Appeal Decision

Appeal Ref: APP/R5510/W/23/3314927

69 High Street, Ruislip, Hillingdon, HA4 8JB

- The appeal is made under section 78 of the Town and Country Planning Act 1990 against a refusal to grant planning permission.
 - The appeal is made by Mr Richard Hennessy of Blubuild.com Limited against the decision of the London Borough of Hillingdon.
 - The application Ref 1983/APP/2022/2930, dated 22 September 2022, was refused by notice dated 17 November 2022.
 - The development proposed is for an extension at the front of the property above the shopfront to provide 1 x self-contained flat (Use Class C3) at second floor level and erection of a new two storey building at the rear of the property to provide 1 x self-contained flat (Use Class C3) above an open loading bay with associated bin and cycle store.
-

Diagram 1 [above]

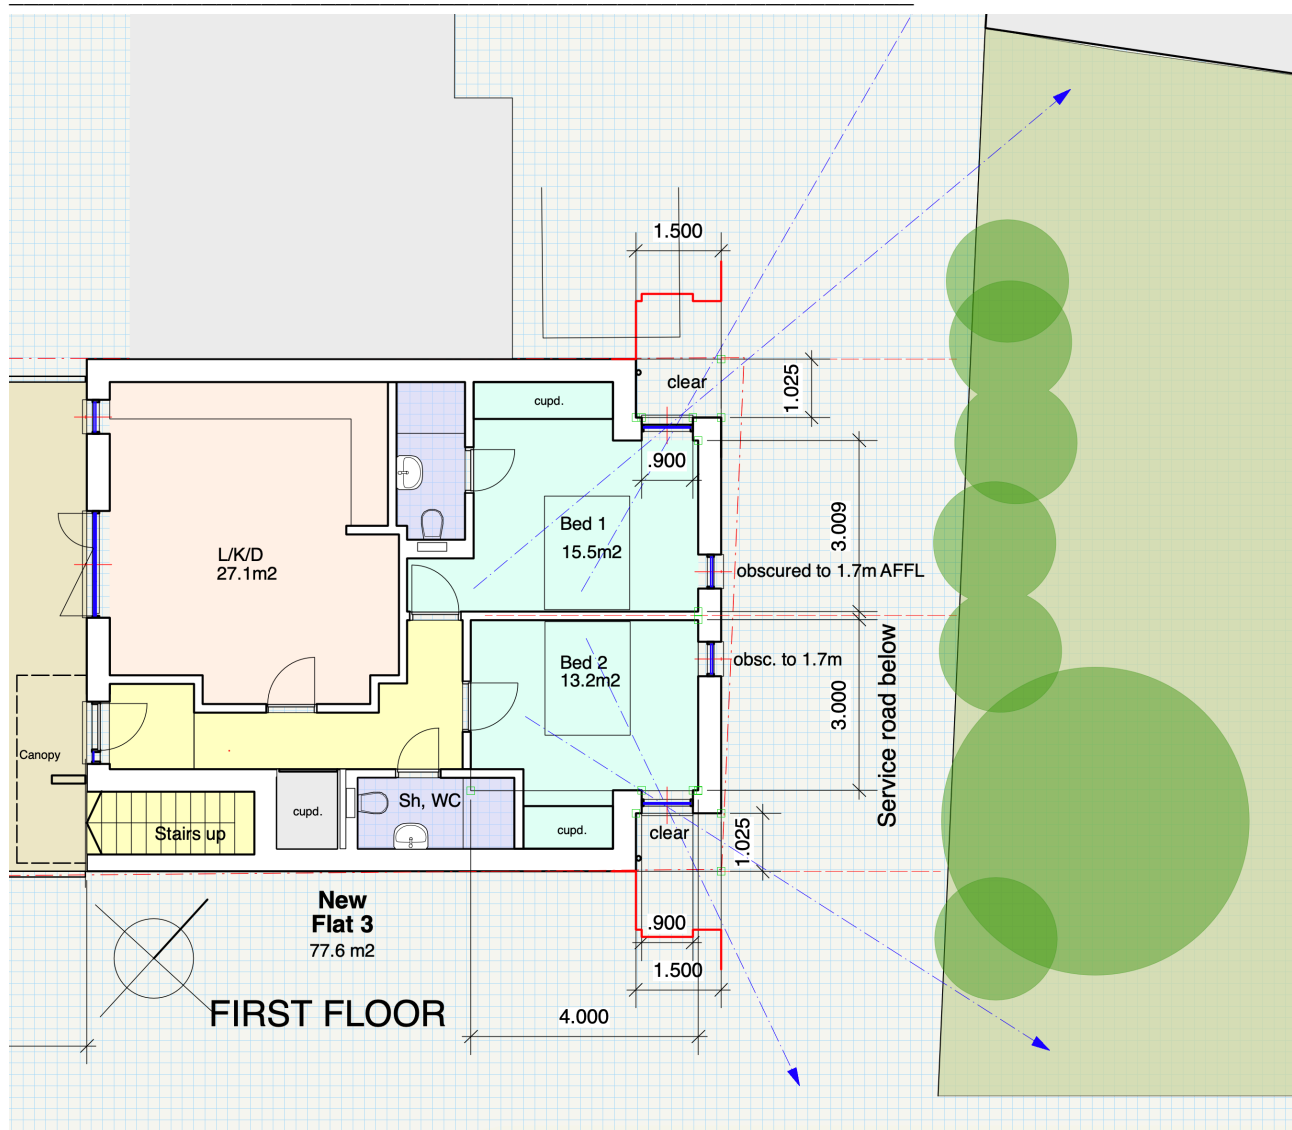
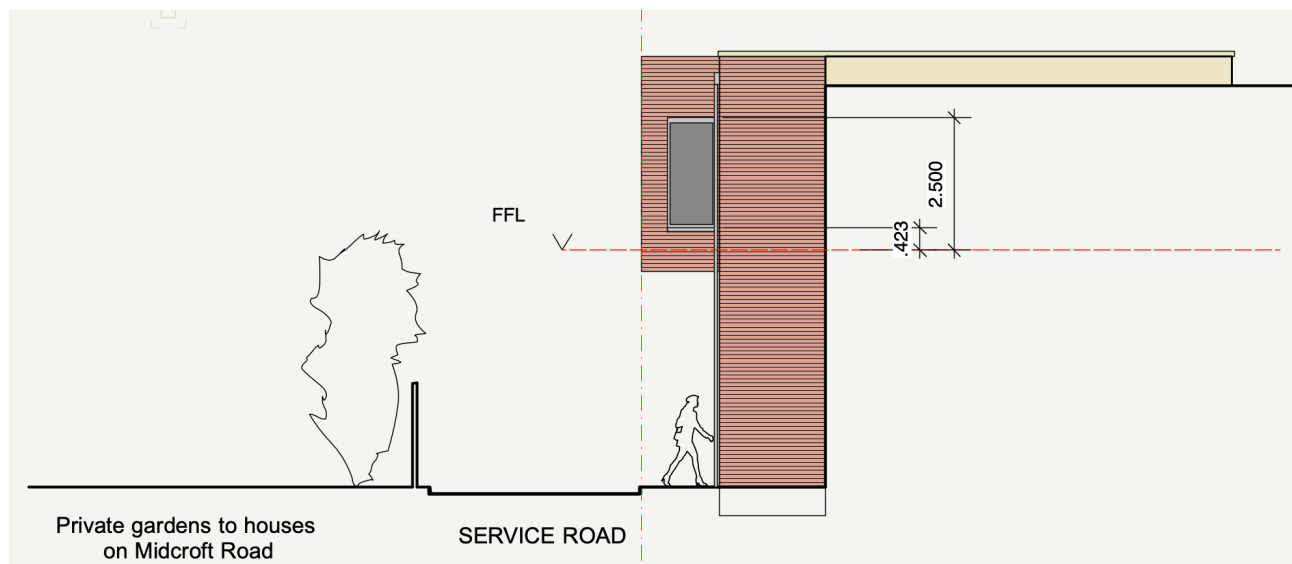
8. The appeal proposal is a resubmission of a previously approved scheme, to include some proposed alterations.
9. The alteration which is of concern is the reduced set-back distance between the side windows of the bedrooms of flat No 3 to the side boundaries of the site. The reduction, results in a set-back from the side boundaries of approximately 1 metre, as opposed to the previously approved set-back distance of approximately 2 metres.

11. In terms of outlook from the side window of bedroom 2, the nearest solid structure would be the side elevation of the projecting rear 2-storey element of Nos 75-79 High Street, which is set a two-plot width (some 15 metres) distance away from the appeal boundary.

12. In terms of outlook from the side window of bedroom 1, there is a metal external staircase leading to the single storey flat roof area at the rear of No 67 High Street. However, this staircase would not be directly in front of the proposed side window of bedroom 1.

boundaries, this still would have had to have borrowed space from the neighbouring sites to ensure appropriate outlook, as there remains the same existing neighbouring context. The reduced set-back from the boundaries of only 1 metre to either side boundary, would not therefore discernibly change the relationship in terms of outlook.
